From: Michael Eastham
Sent: 15 April 2019 11:43
To: 'Ian Gledhill'
Cc: Planning.Responses
Subject: RE: BE/3/19/DOC - Salt Box - request for an Extension of Time (EoT)

Michael, I've now reviewed the revised CMP. On the basis of the information within the CMP (Rev A (3.0)), the condition can be discharged. For clarity, the information included in appendix 6.0 (Construction Method Statement) is noted as being in draft only. Therefore whilst this includes details of temporary access, these are taken as indicative with the details in the body of the CMP being the details to be adhered to.

Appendix 6.0

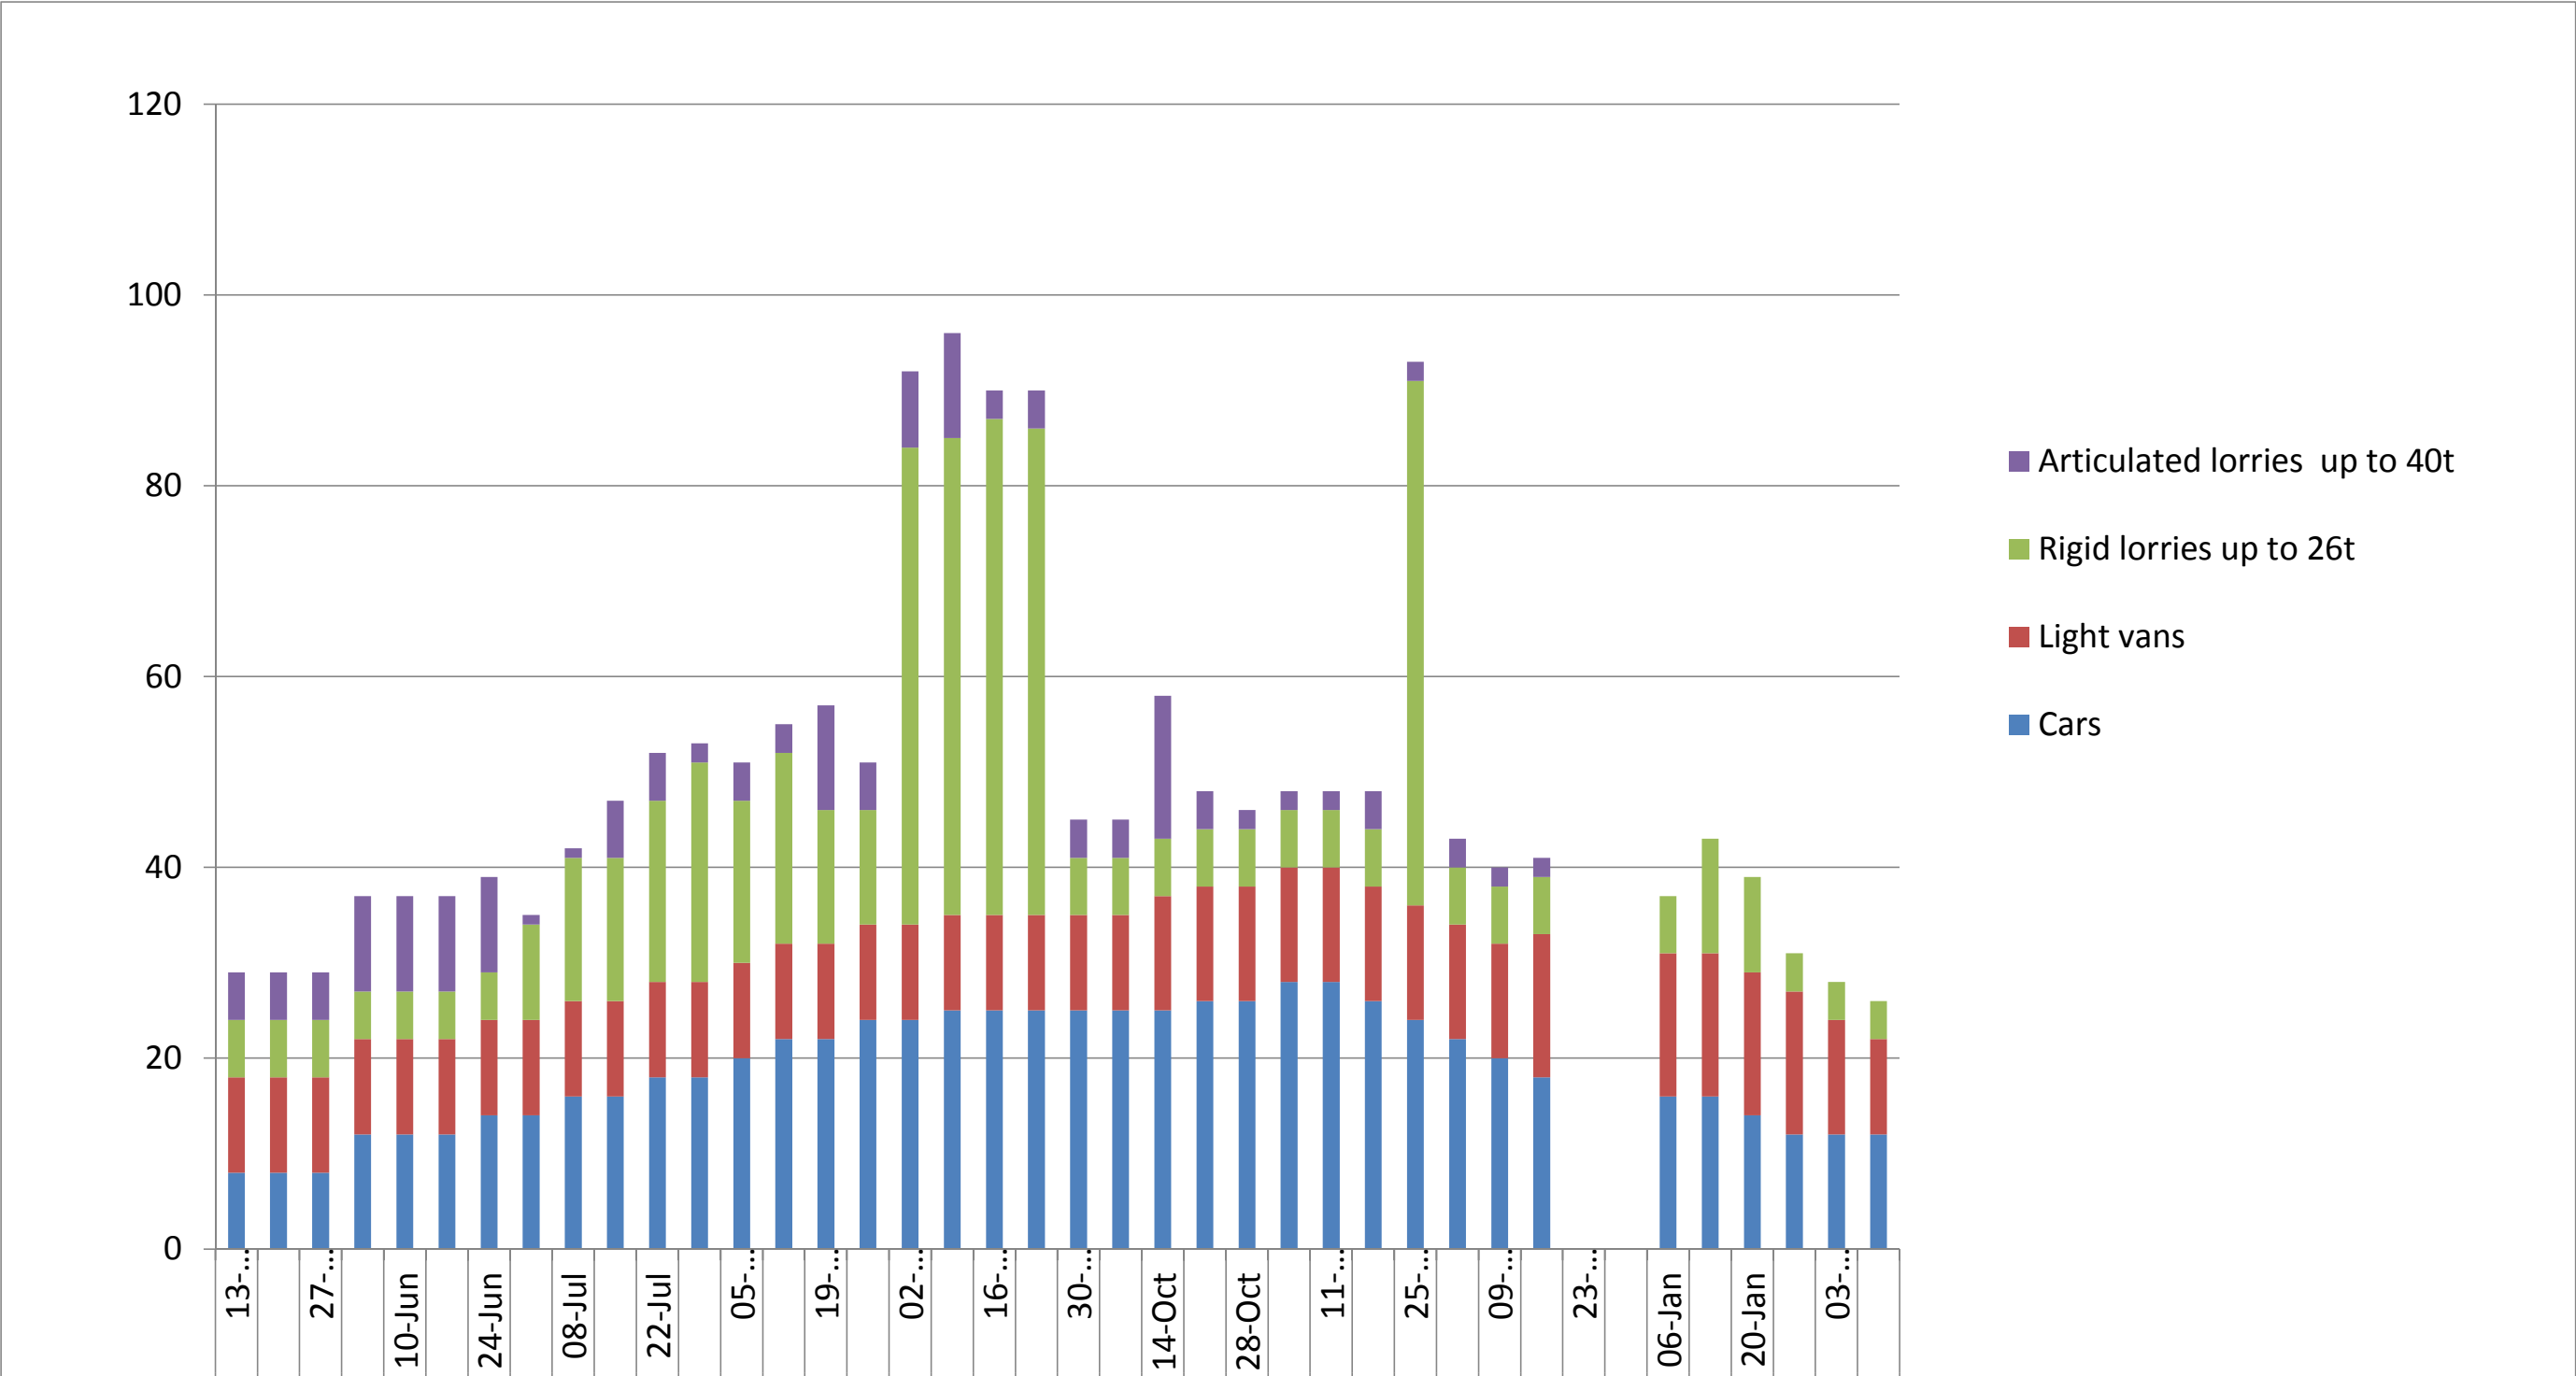
The Construction Method Statement prepared by Midas is out of sync as this was prepared prior to it being agreed that the new access would be constructed in week 1-4 to provide access from the A29/ A259 roundabout.

Ok, thanks. I'm still content for the condition to be discharged. As necessary that section which is drafted will presumably be prepared and appended to the CMP once finalised.
